Application for a non-material amendment following a grant of planning permission.

Non-material amendment following the grant of EP/17/16/PL to change extent of new cladding, change to position of covered access between office & clubhouse, retention of existing position for north facing entrance door & change to west facing window of lounge area of clubhouse.

INSTALLATION OF NEW WINDOWS, EXTERNAL DOORS AND CLADDING TO CLUBHOUSE AND COVERED ACCESS BETWEEN OFFICE AND CLUBHOUSE

EP/177/16/PL

DATE: 28.11.2016 DRG No. 4 Amended 11/12/2017 Amended 26/01/2018

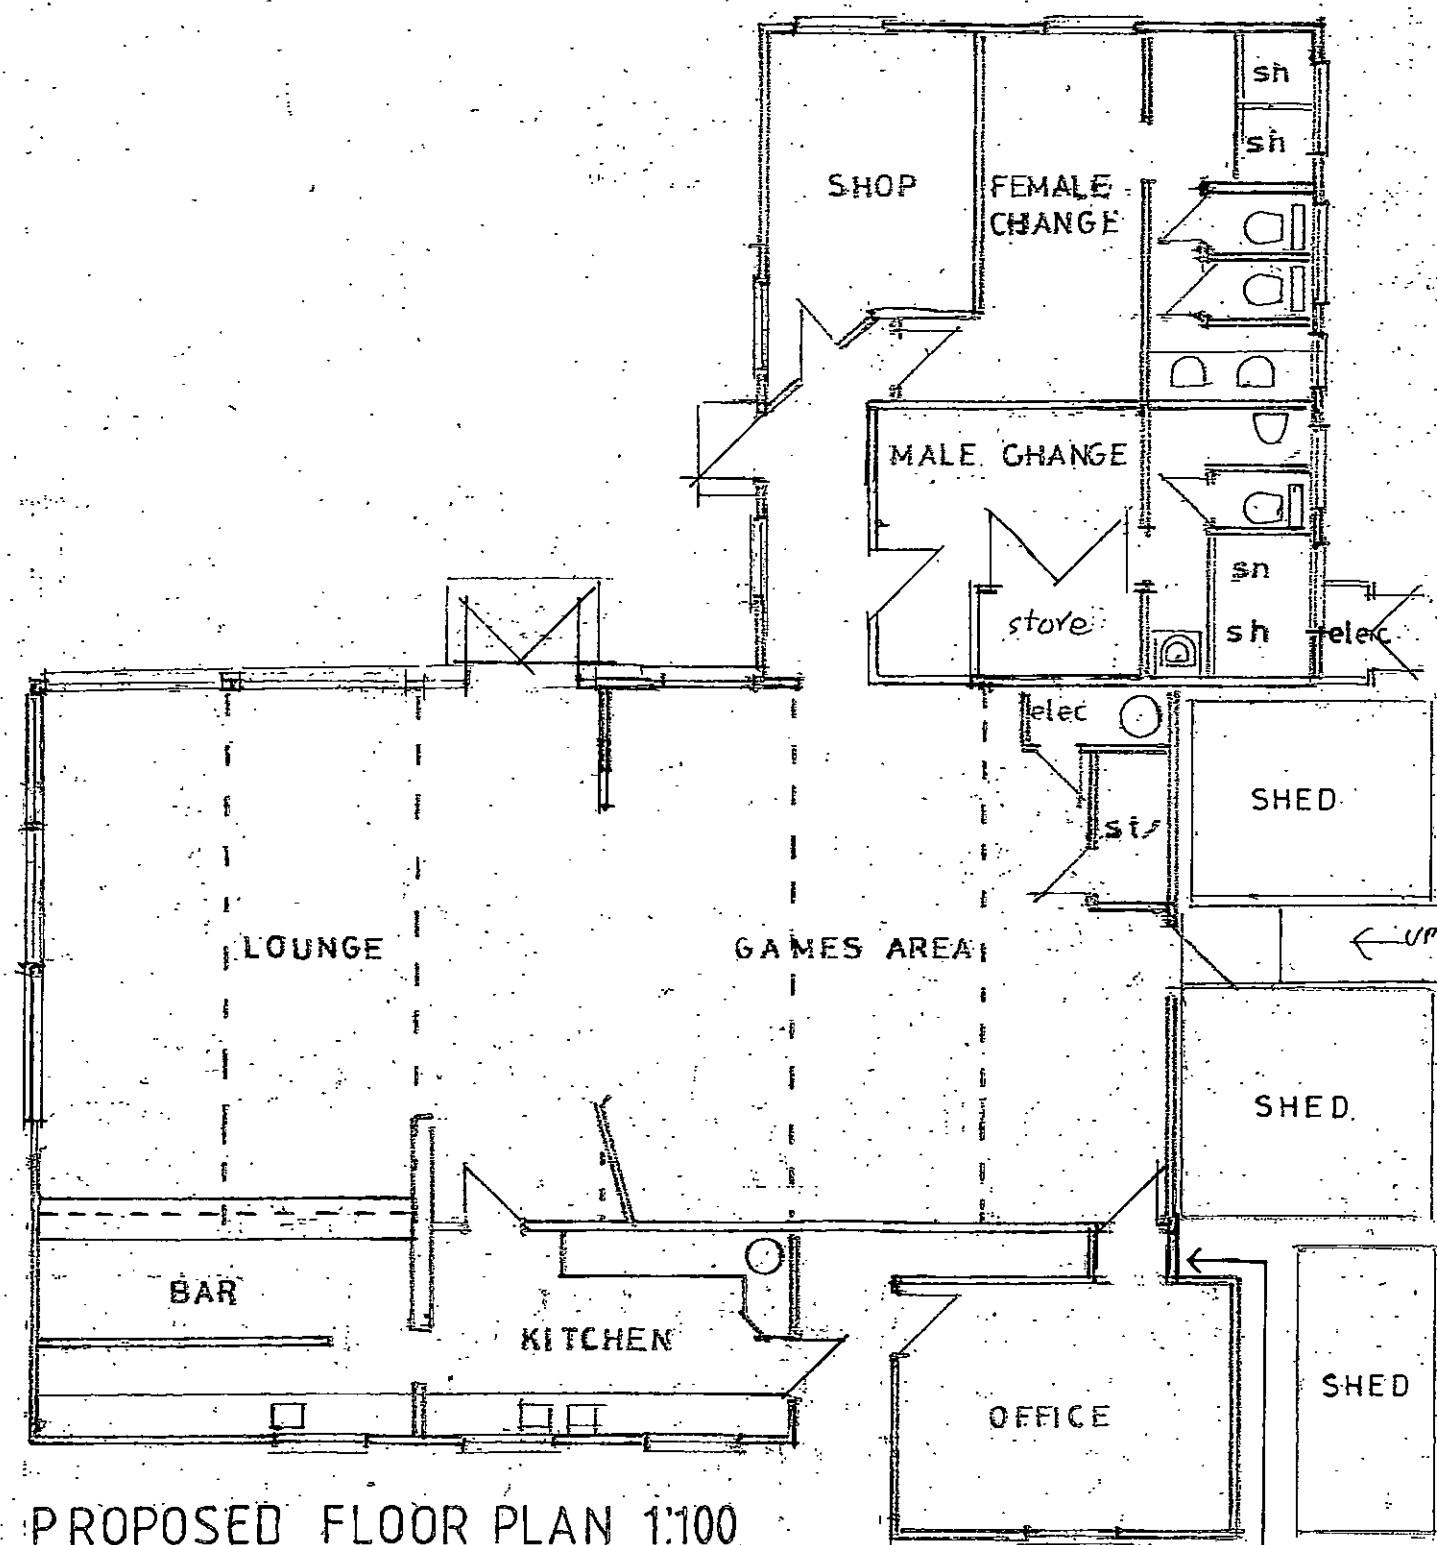
1. CHANGES TO THE EXTENT OF THE NEW CLADDING.
2. A CHANGE TO THE POSITION OF THE COVERED ACCESS BETWEEN THE OFFICE AND THE CLUBHOUSE.
3. THE RETENTION OF THE EXISTING POSITION FOR THE NORTH-FACING ENTRANCE DOOR.
4. A CHANGE TO THE WEST FACING WINDOWS OF THE LOUNGE AREA OF THE CLUBHOUSE.

4 DATED 28/11/2016 5 DATED 28/11/2016 6 - DATED 28/11/2016

4, 5 + 6 ALL WITH AMENDED DATE 26/01/2018
